## Jeanie Bourke - Re: 30 Monument St. Bp#2014-02773

**From:** Jeanie Bourke  
**To:** Brewster Buttfield  
**Date:** 3/6/2015 1:29 PM  
**Subject:** Re: 30 Monument St. Bp#2014-02773  
**CC:** George Froehlich; Jamie Isaacson; Tammy Munson; Tom Landry

Thank you for providing these changes and details. I have reviewed the information, see my comments below in red. This will need to be submitted formally as an amendment to the original permit. The application is the Residential Alterations/Additions, and you can reference the permit in the description along with the additional changes.

4 NORTH ELEVATION
 1/4" = 1'-0"

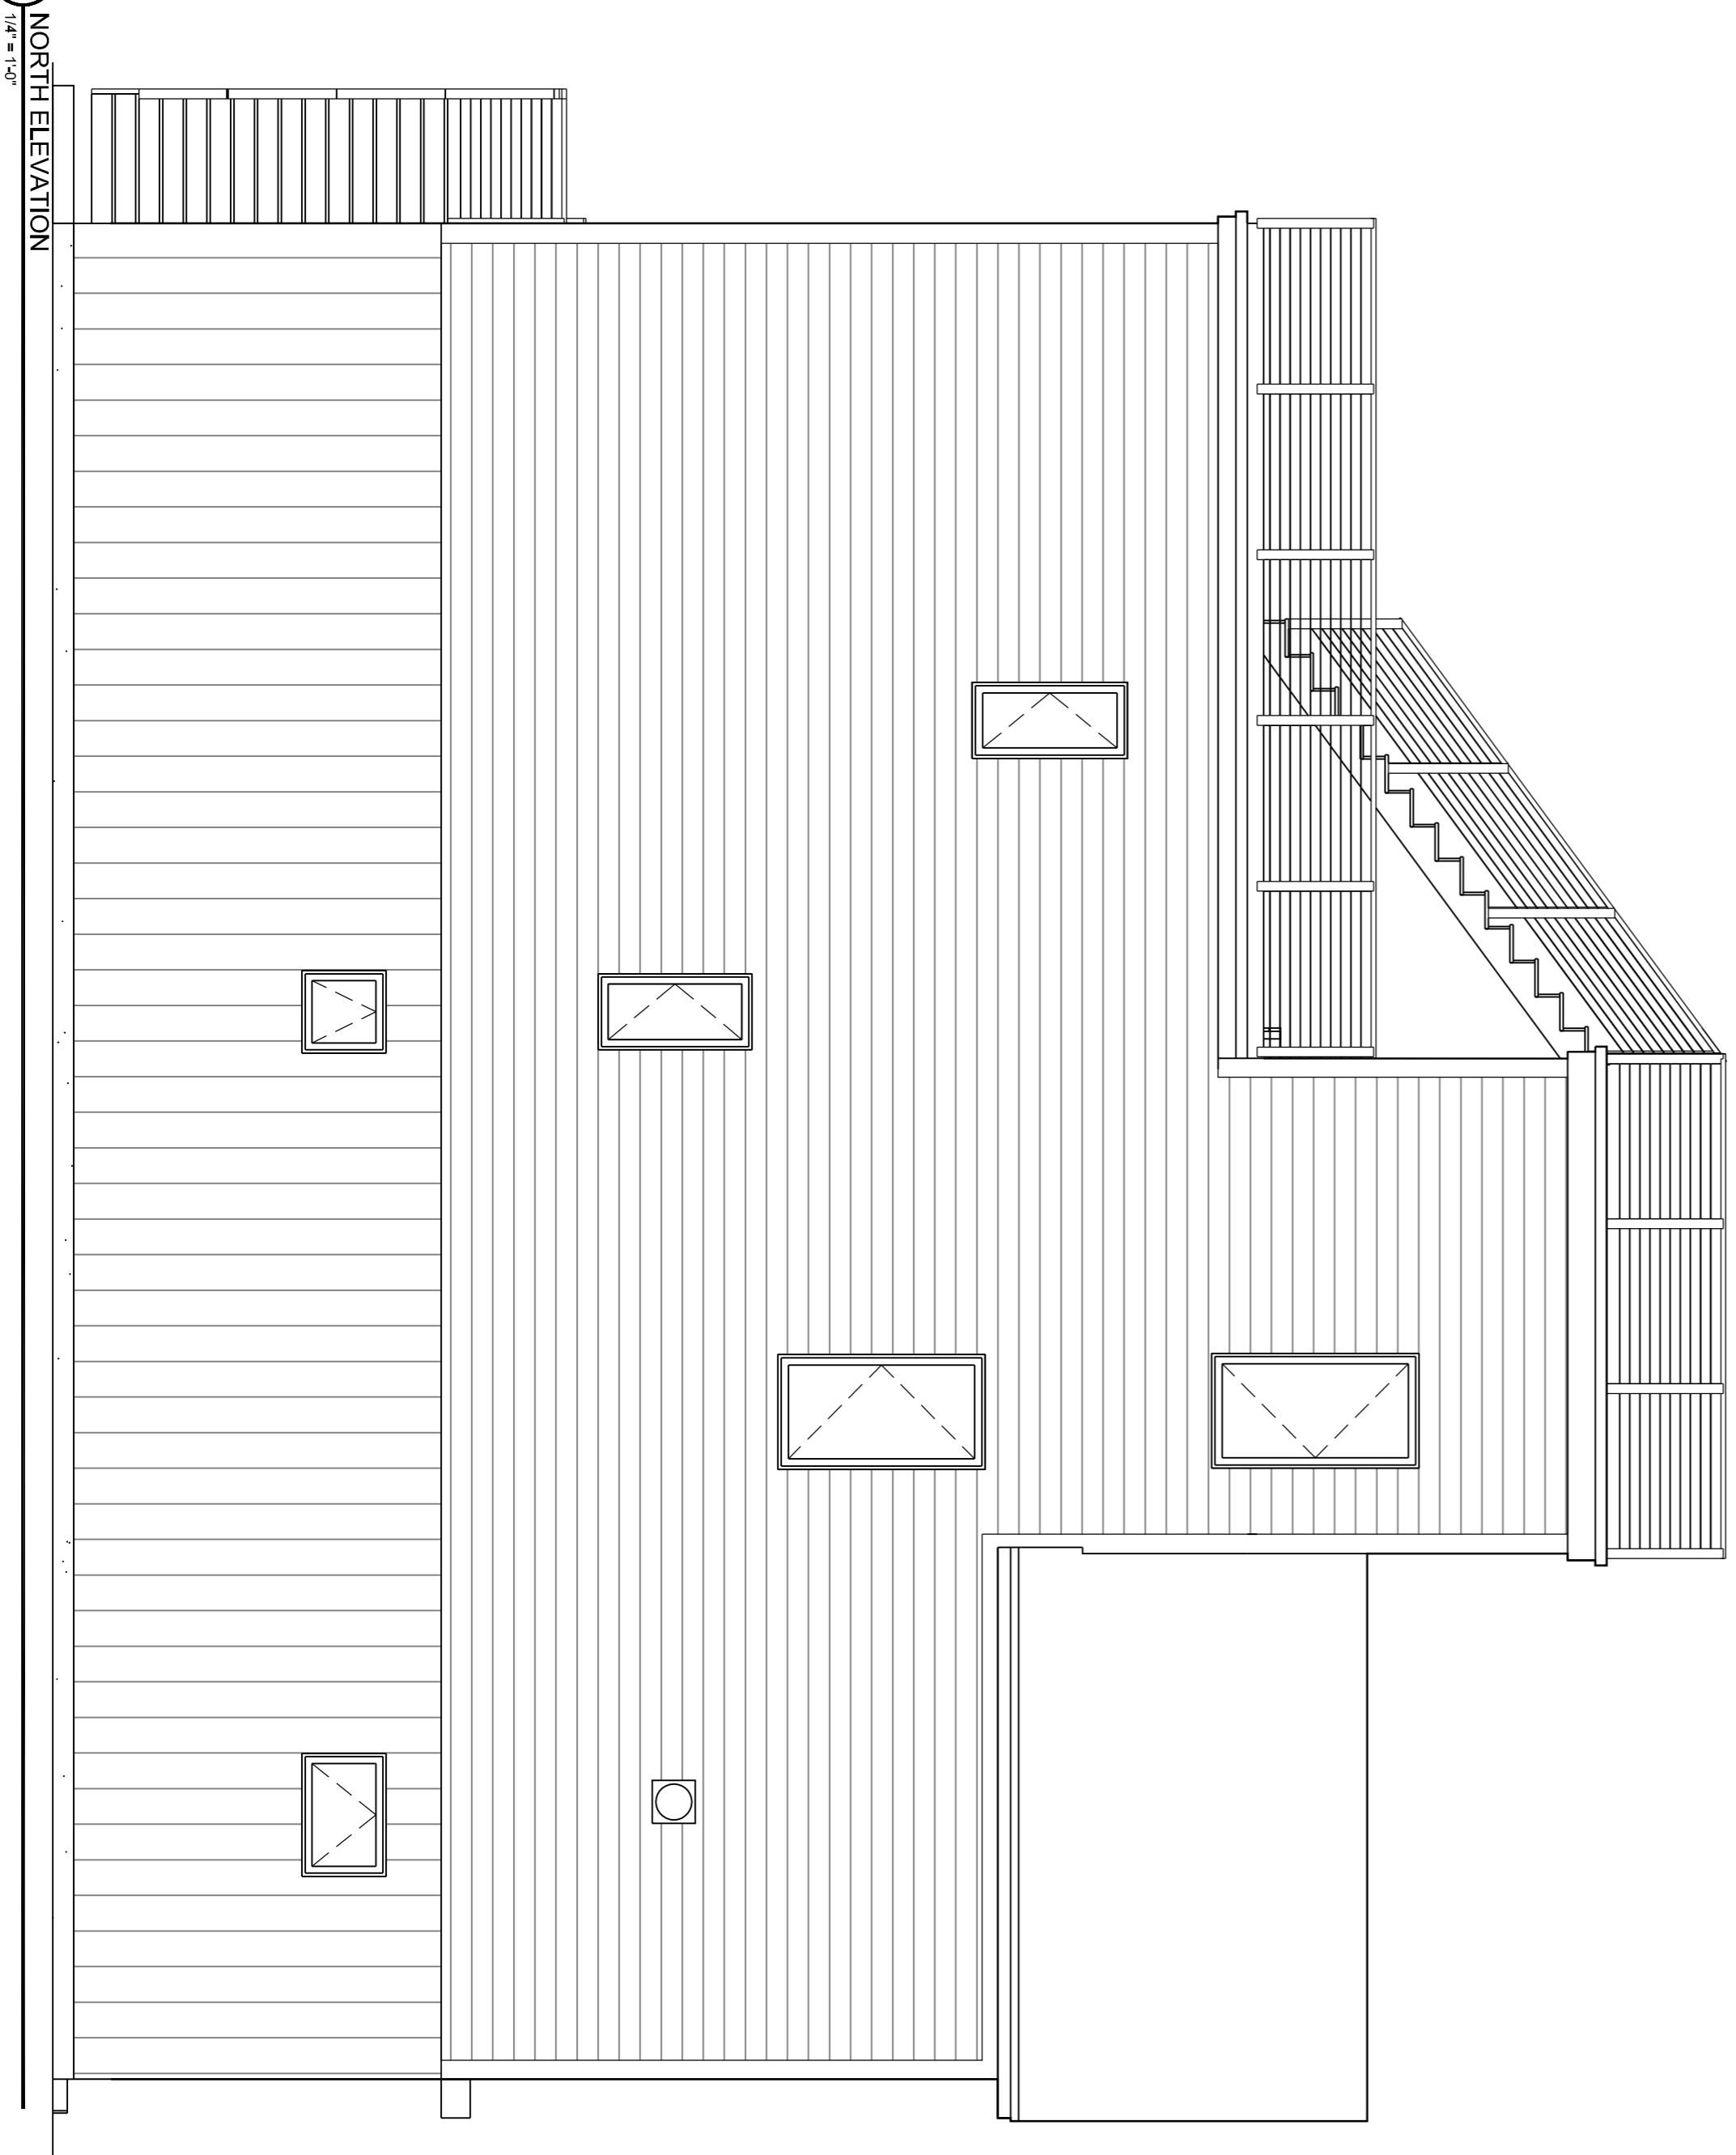
2. The window quantity is actually the same if you can the original basement windows (see photo below). The actual area of glass is reduced in the proposed plan by 17 sq.ft. This is shown on the existing and proposed elevation drawings. This is acceptable.

1. Provide a 1 hour exterior wall detail, rated from both sides per Table 302.1 and UL 263 for the northeast wall.
2. Provide the percentage of glazing & openings of the existing and proposed northeast wall. With this

SHEET TITLE  
**BASEMENT PLAN**  
CONSTRUCTION SET

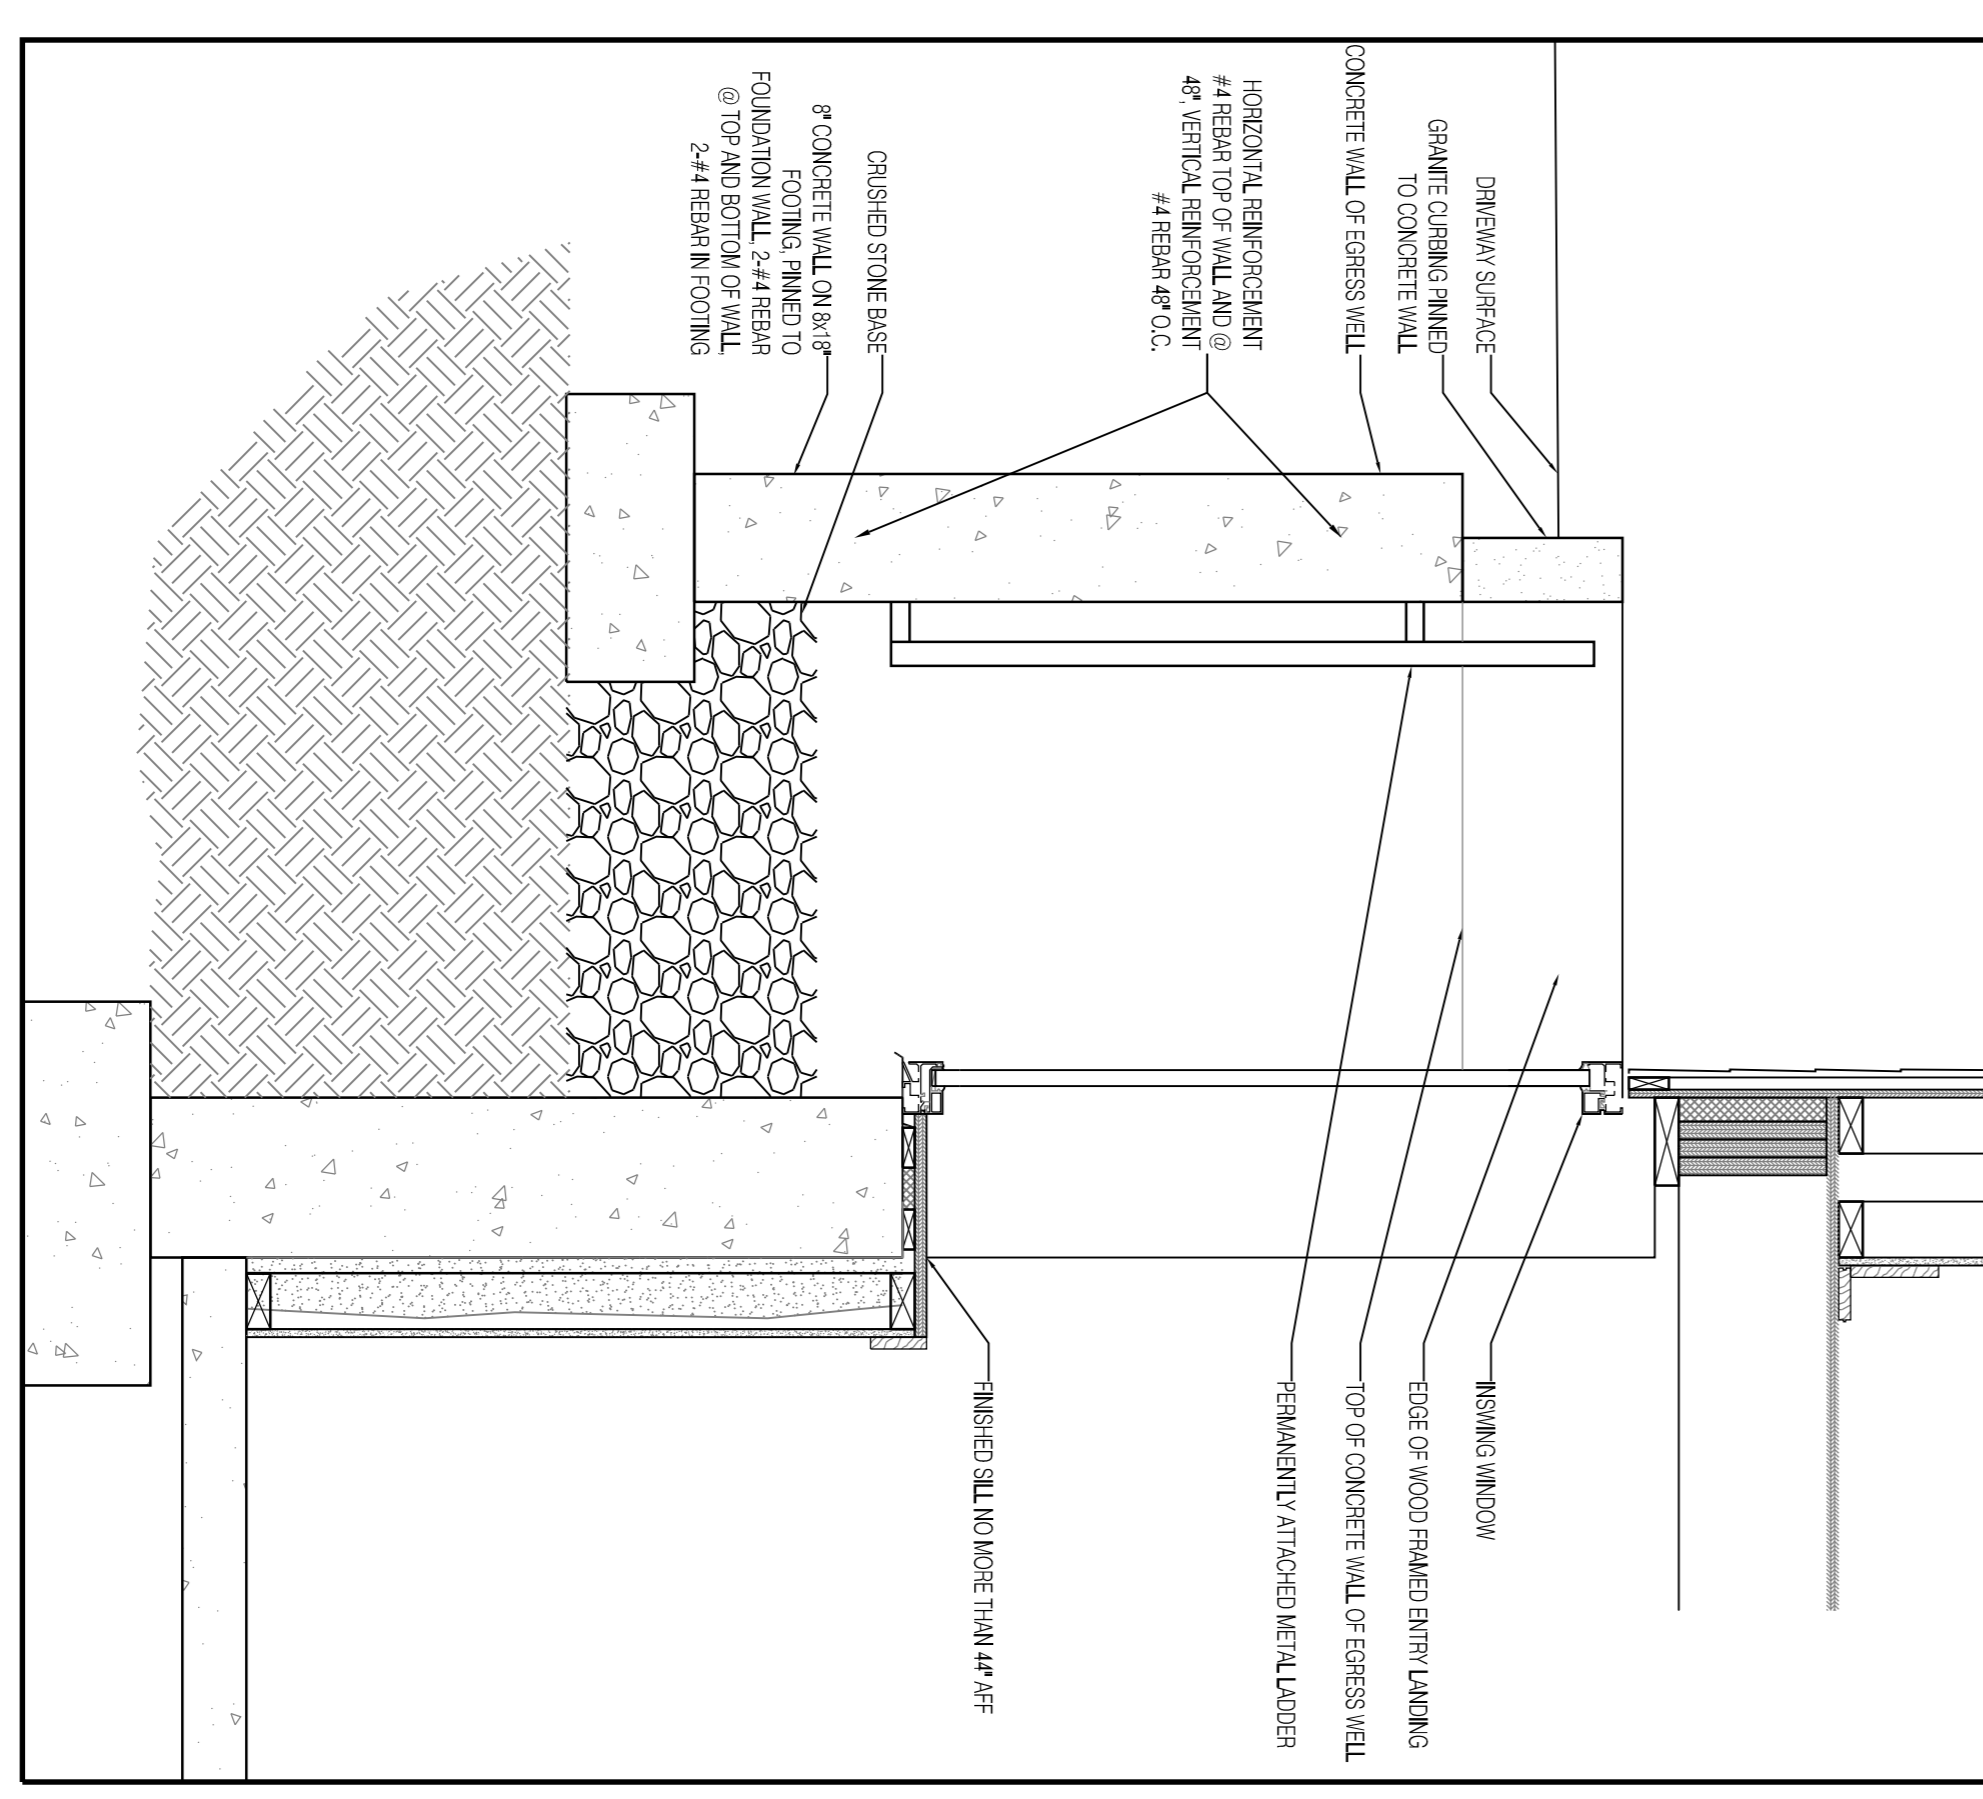
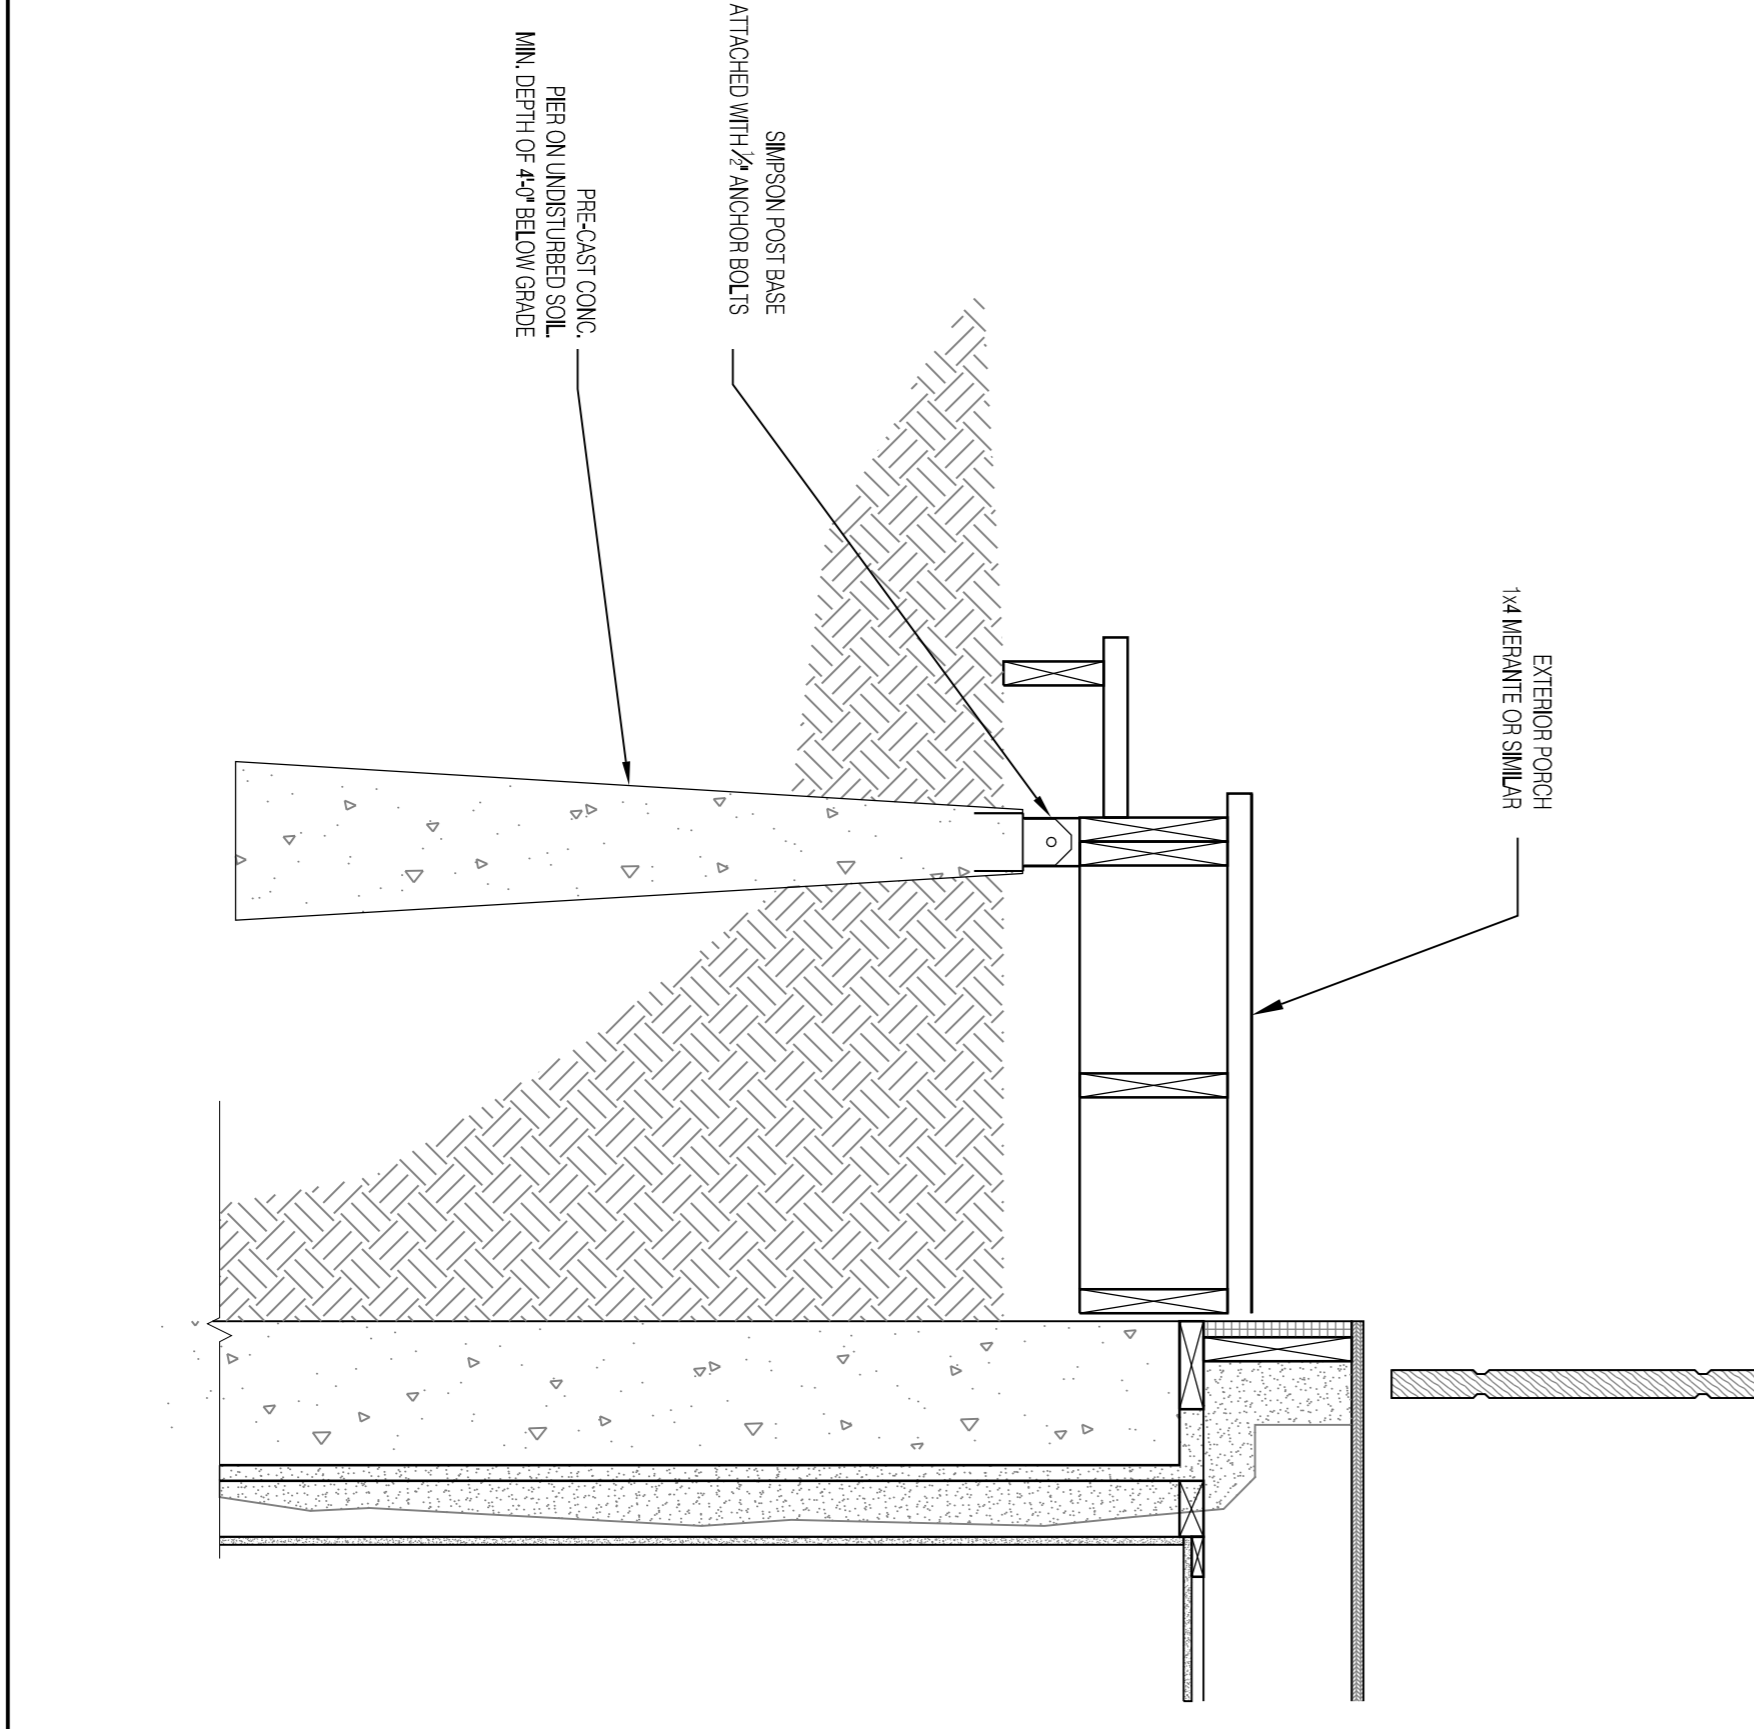
3. An updated plan for the deeper basement is a new sheet, A-103. It shows the required egress well, the stairs to basement instead of a hatch and the required thermal barrier for the insulation. This, as well as any other changes need to be updated on all associated plans, ie. sections, etc.

3. Based on the field inspection by George for the footings, it was confirmed with the contractor that the house will have a full basement. If this is correct, an amendment is required for this change and should include the access and emergency escape and rescue opening.
